Tandridge District Council Principal Areas of Disagreement Summary Statement	Gatwick Airport Norther Runway Project Development Consent Order	Version: v1 Submitted: 20 th October 2023
---	---	---

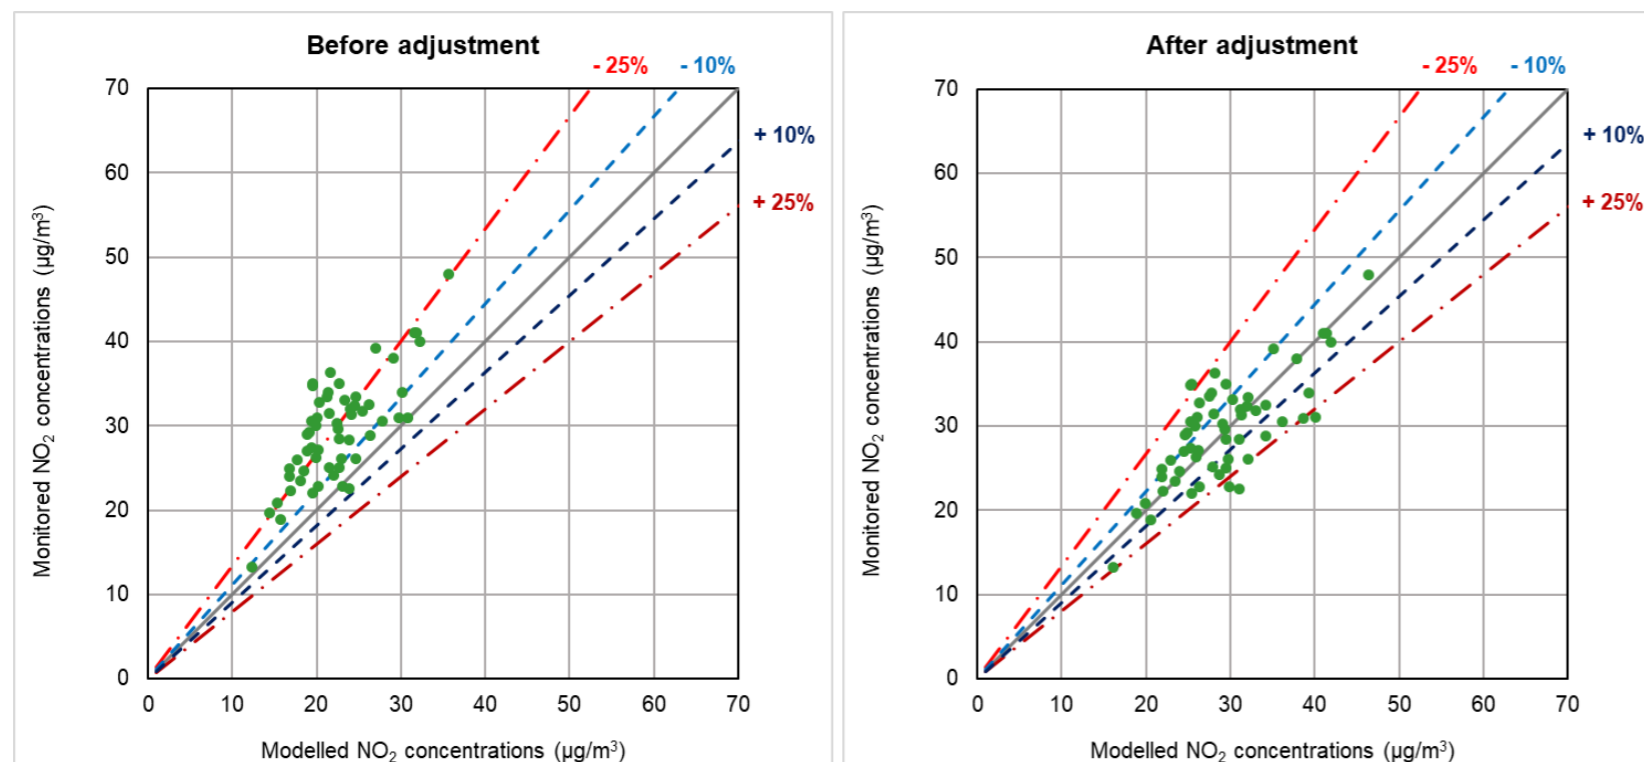
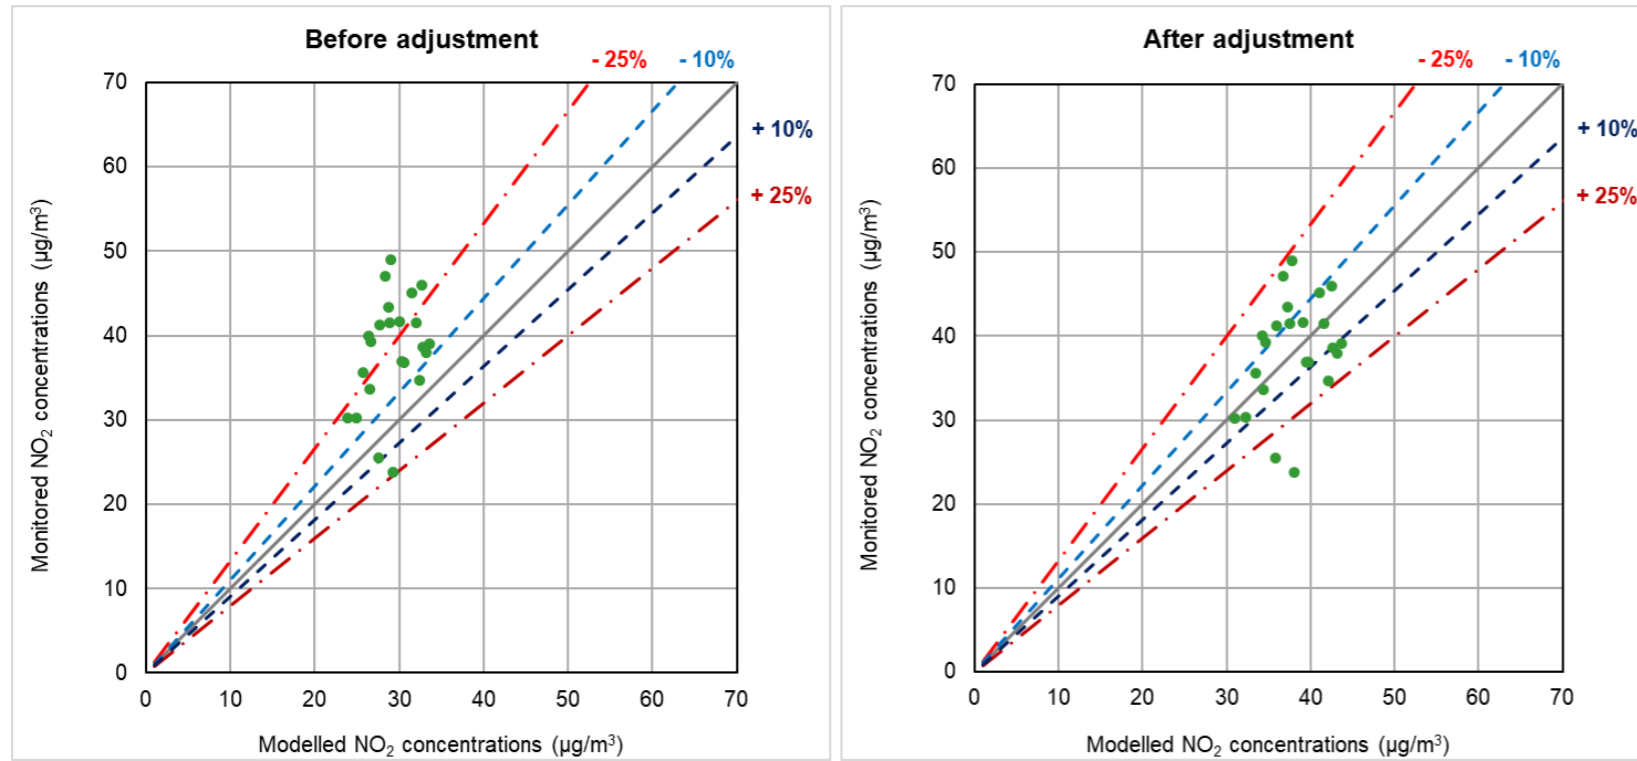
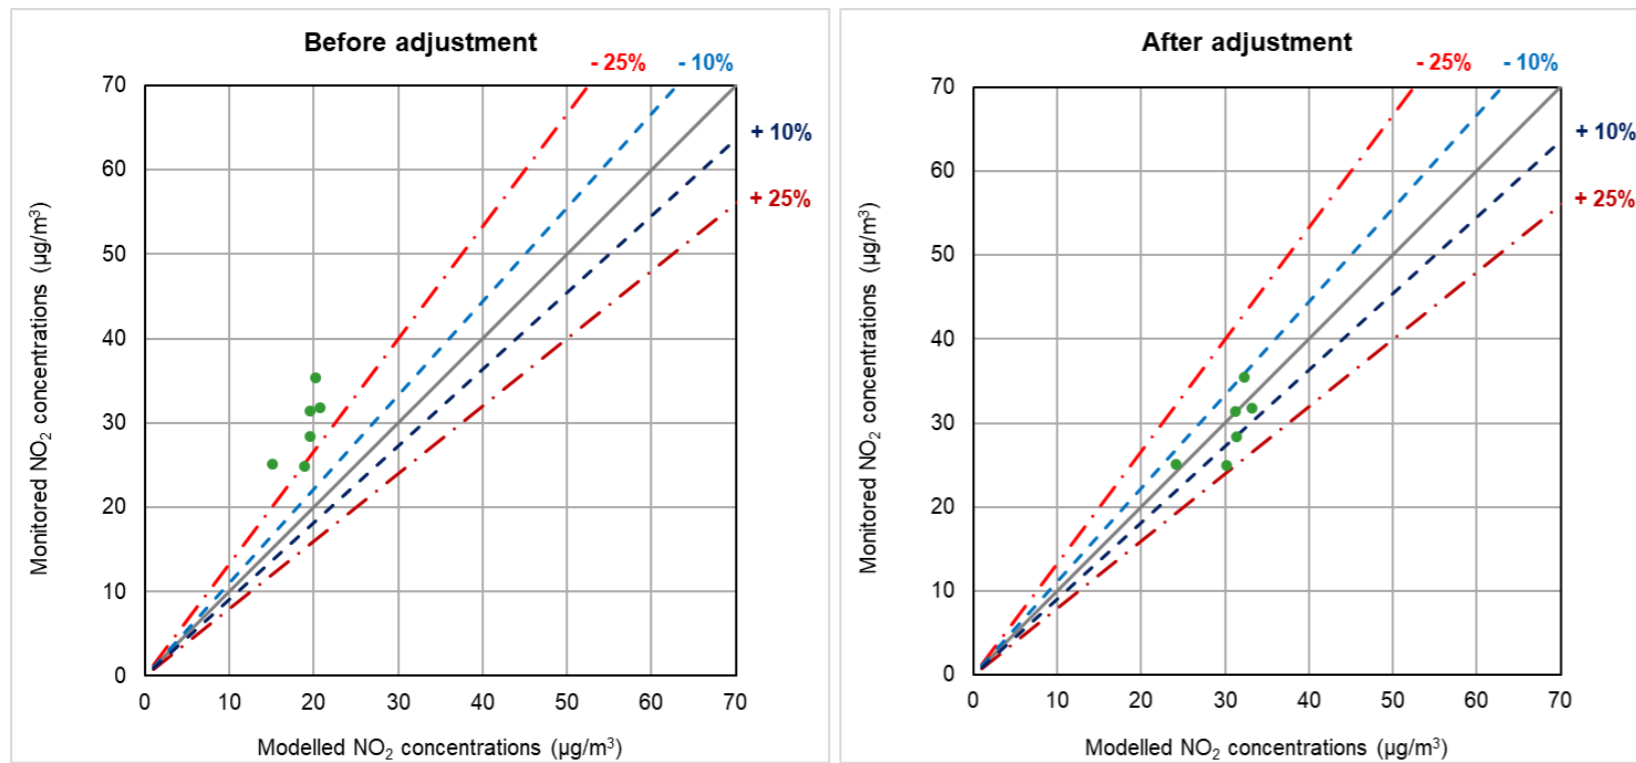
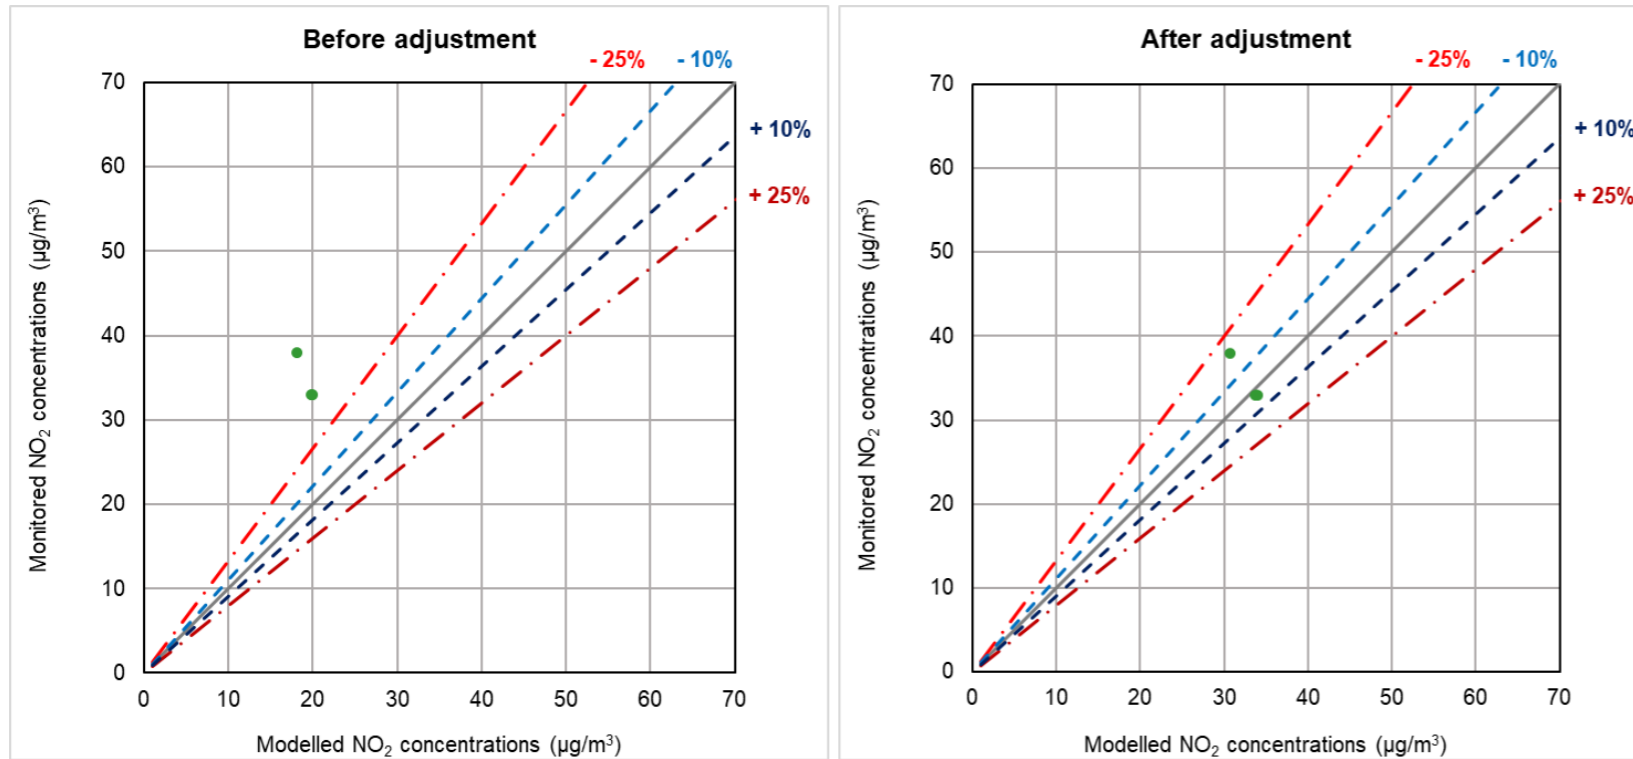
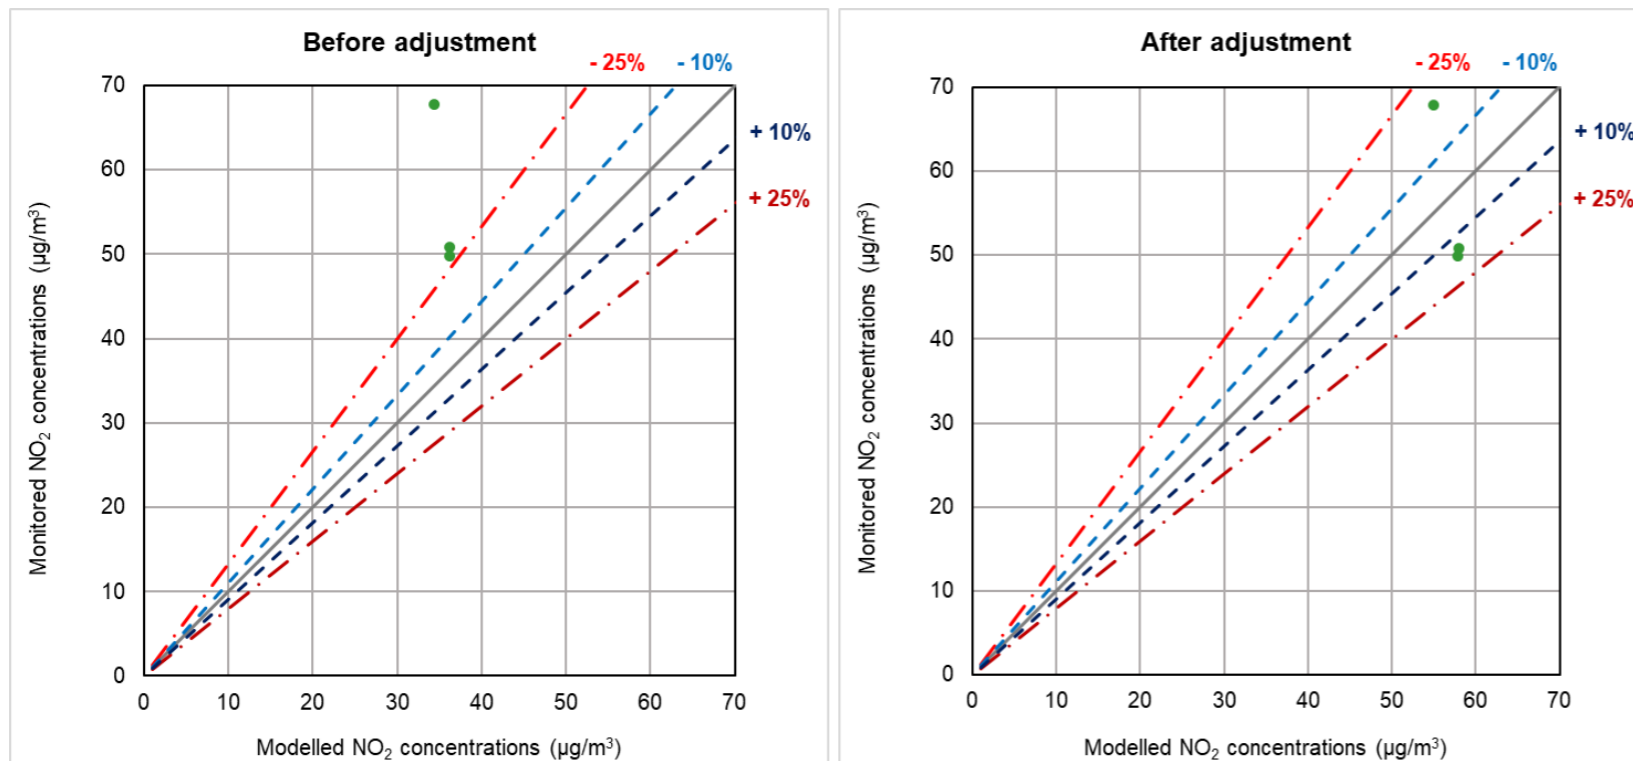
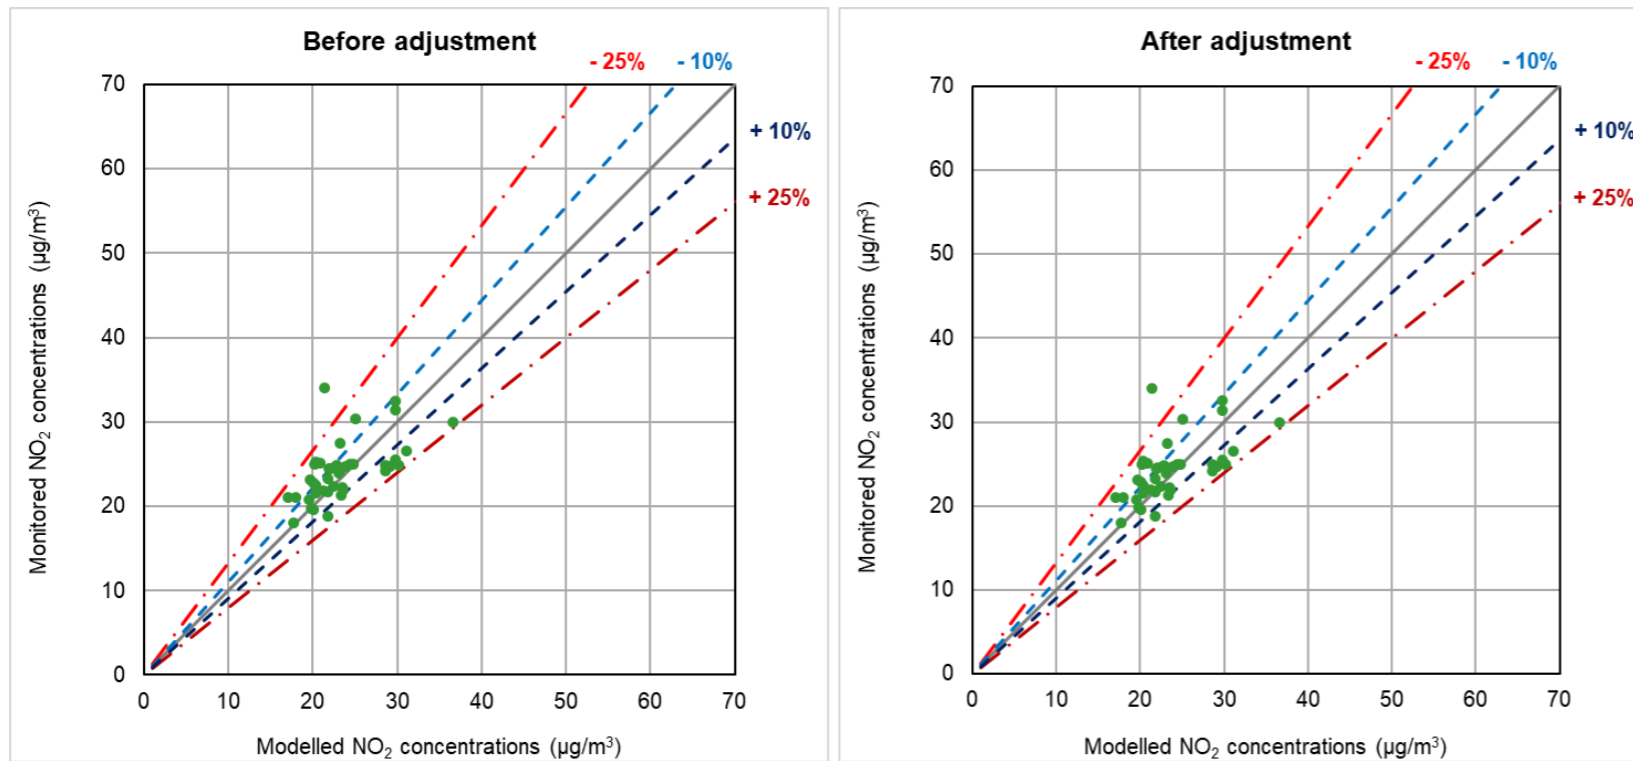
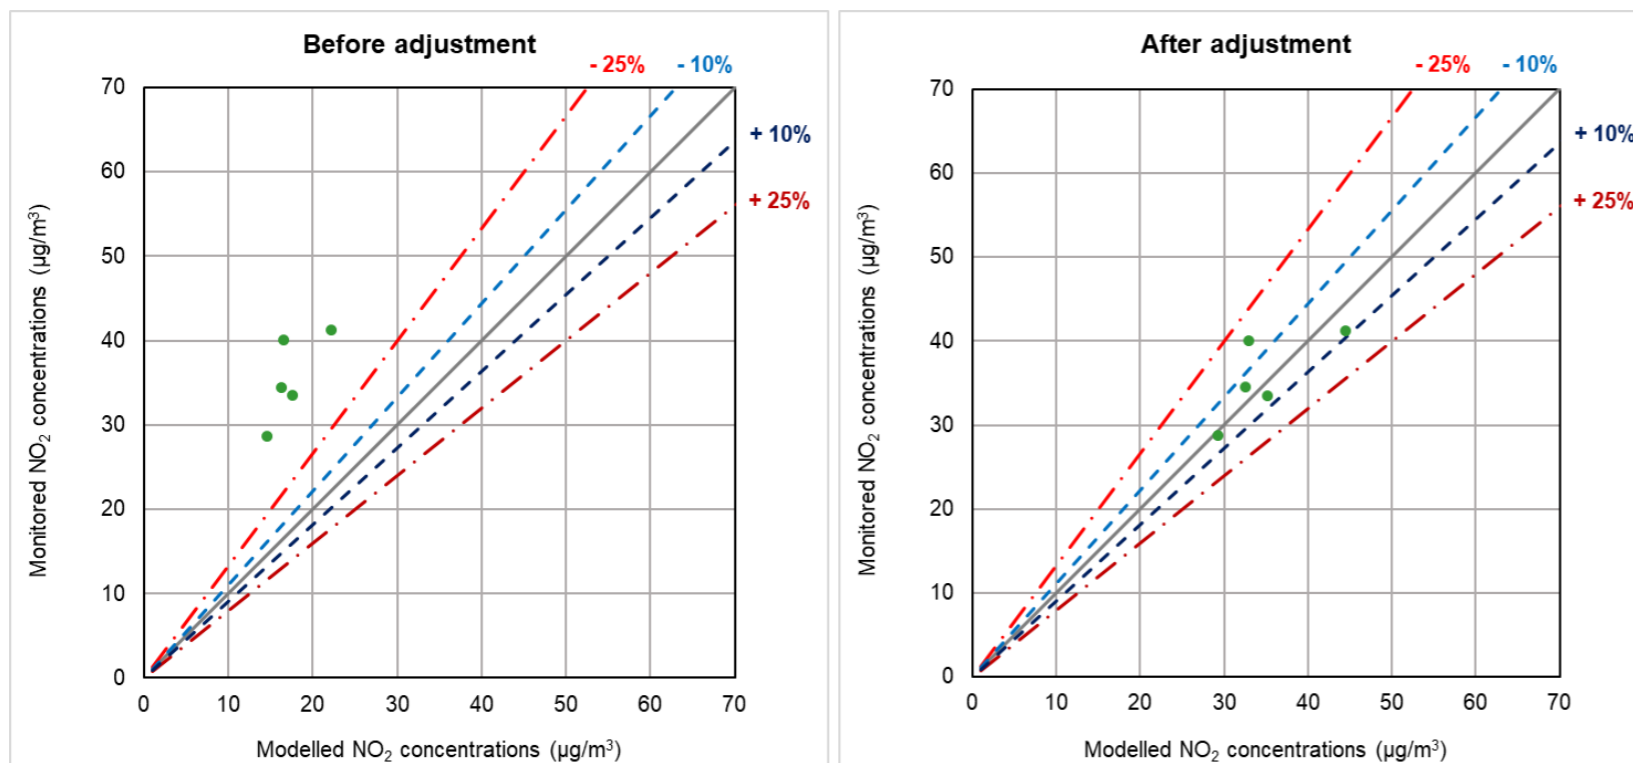
Principal Issue in question	Concern held	What needs to change/be amended/be included in order to satisfactorily address the concern	Likelihood of concern being addressed during Examination
AQ06: Monitoring sites	TDC is concerned that excessive numbers of monitoring sites may have been excluded from model verification which could have improved the quality of the air quality verification and so the confidence in outputs.	Further details on the sites excluded on this basis is required. Further details could be added to Table 3.2.2 of Environmental Statement Air Quality Appendix 13.6.1 to address the clarification points.	Uncertain
AQ07: Verification zones	TDC disagrees that enough justification was provided for the selection of different verification zones and why the model would be expected to perform differently in each area. A sensitivity test is required to demonstrate that the conclusions of the assessment would not change if a single verification factor were used.	A sensitivity test is required to demonstrate that the conclusions of the assessment would not change if a single verification factor were used.	Uncertain
